From: Simon Davis
Sent: 21 April 2020 12:45
To: 'Ben Daines' [REDACTED]
Cc: 'Chris Barker' [REDACTED]
Subject: RE: BE/137/19/RES

I find the general layout (Rev 05) supportable, although I remain concerned about a number of items (surface water drainage strategy, patios, fencing) proposed within the RPA of retained trees. Those I expect to be addressed within the revised AIA/MS and/or considered by the architect/drainage engineer for revision, to gain my full support.

Drawing Title
Detailed Site Plan

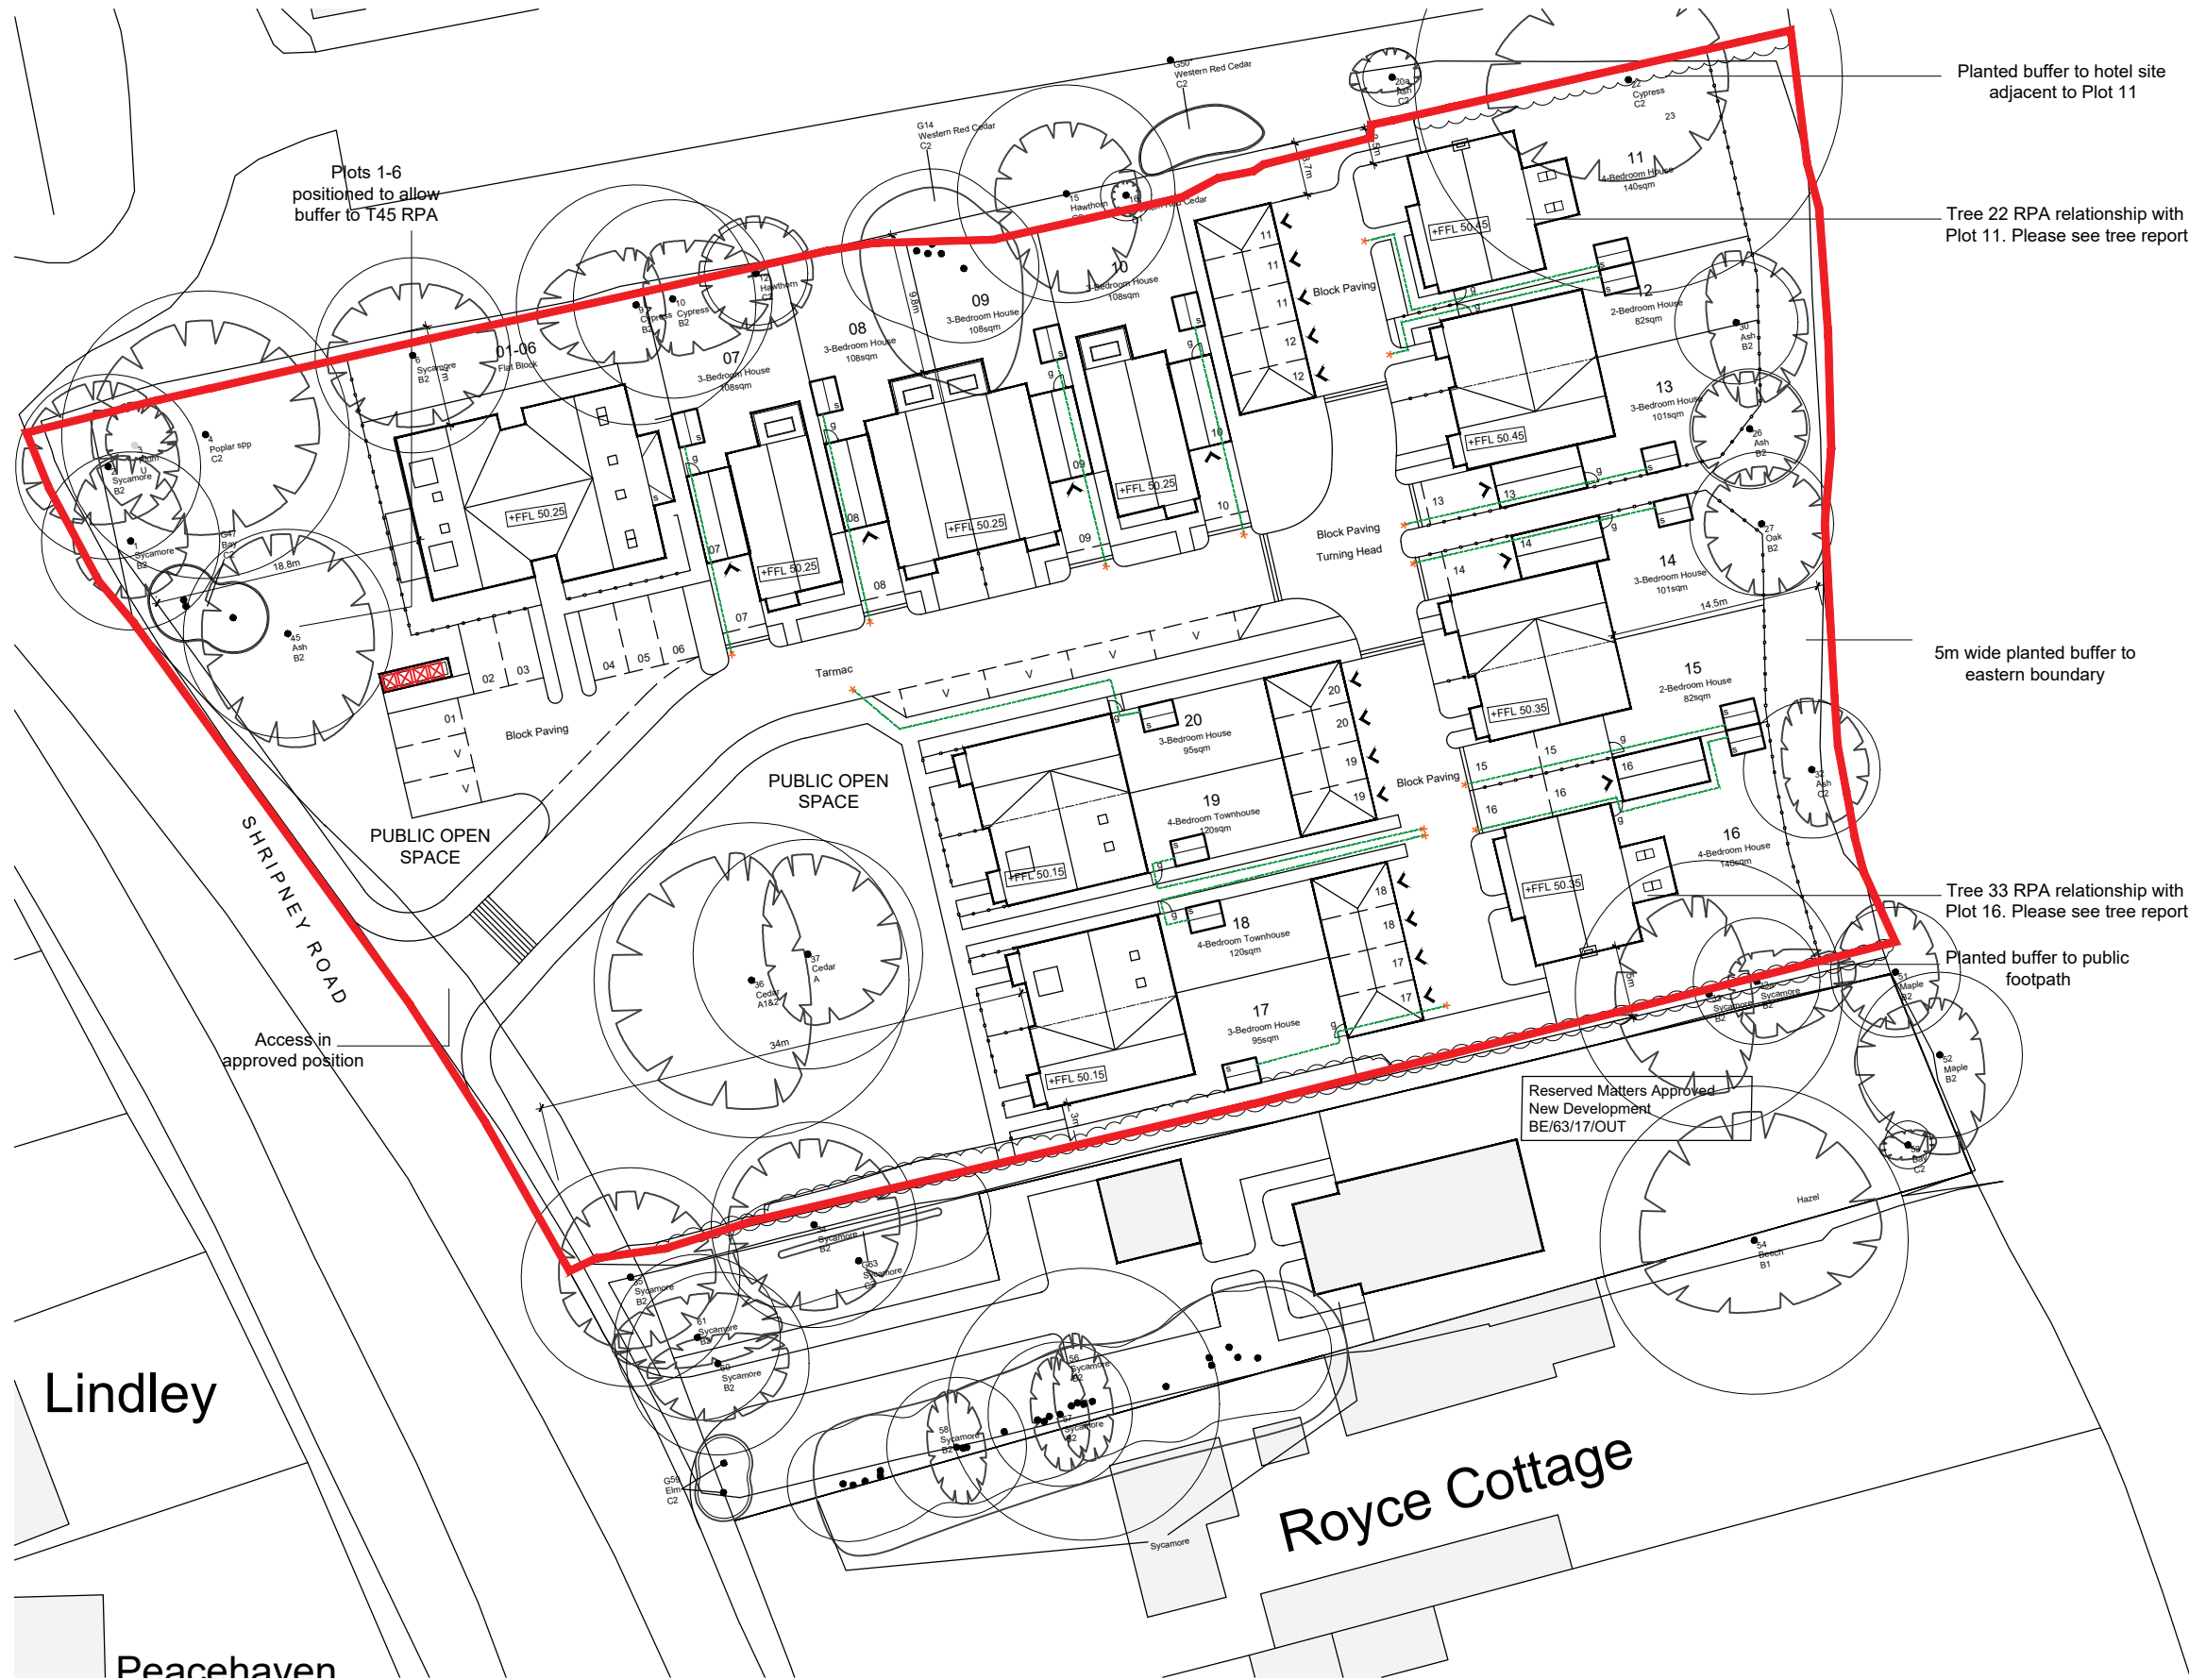
"The dimensions are about right – I have attached documents relating to Turning radius for our vehicle. Looking at the map you attached it all looks ok, but as with all these developments a lot depends on how the residents park. It might be worth pointing out that any block paving would have to be able to withstand the weight of the vehicle making a tight turn into and out of the turning area – this would put down a fair bit of "scrub" from rear wheels."

Therefore, this satisfies the WSCC comment about refuse vehicles.

Drawing Title: Tree Protection Plan

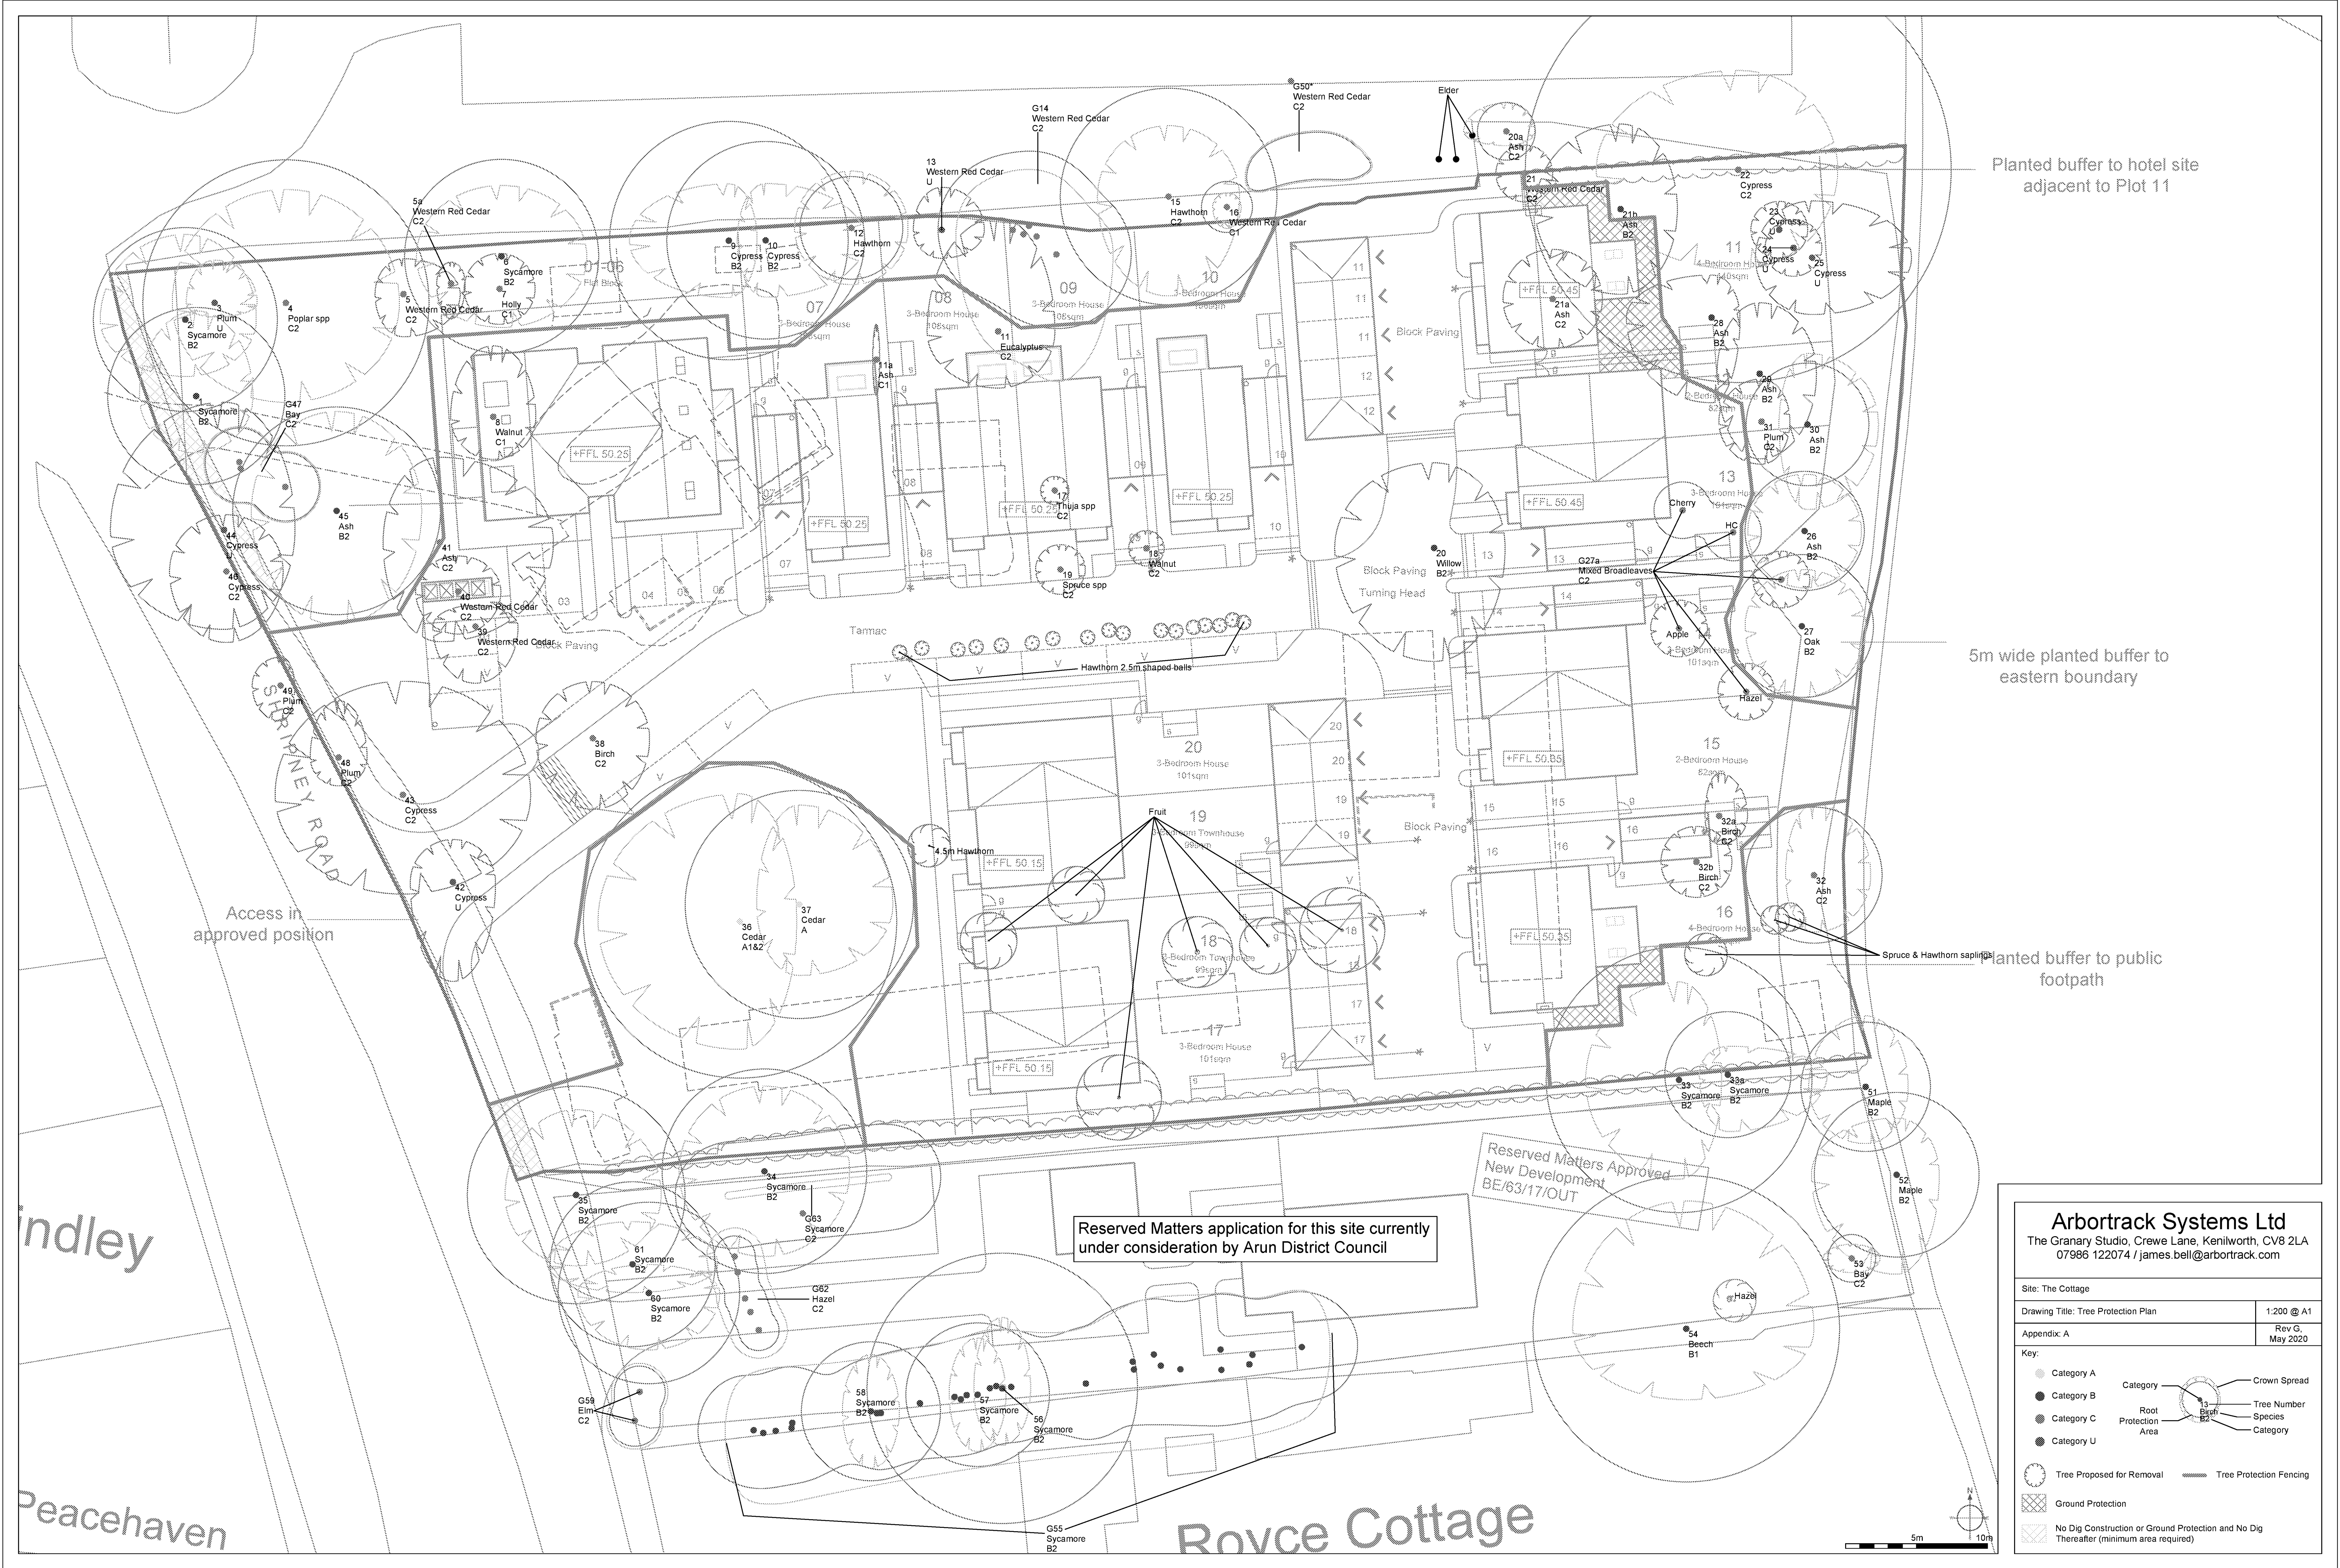
Amending the AIA/MS to address my initial comments and updating the Tree Protection Plan in association with Site Layout, Rev 05 are certainly worthwhile exercises at this stage.
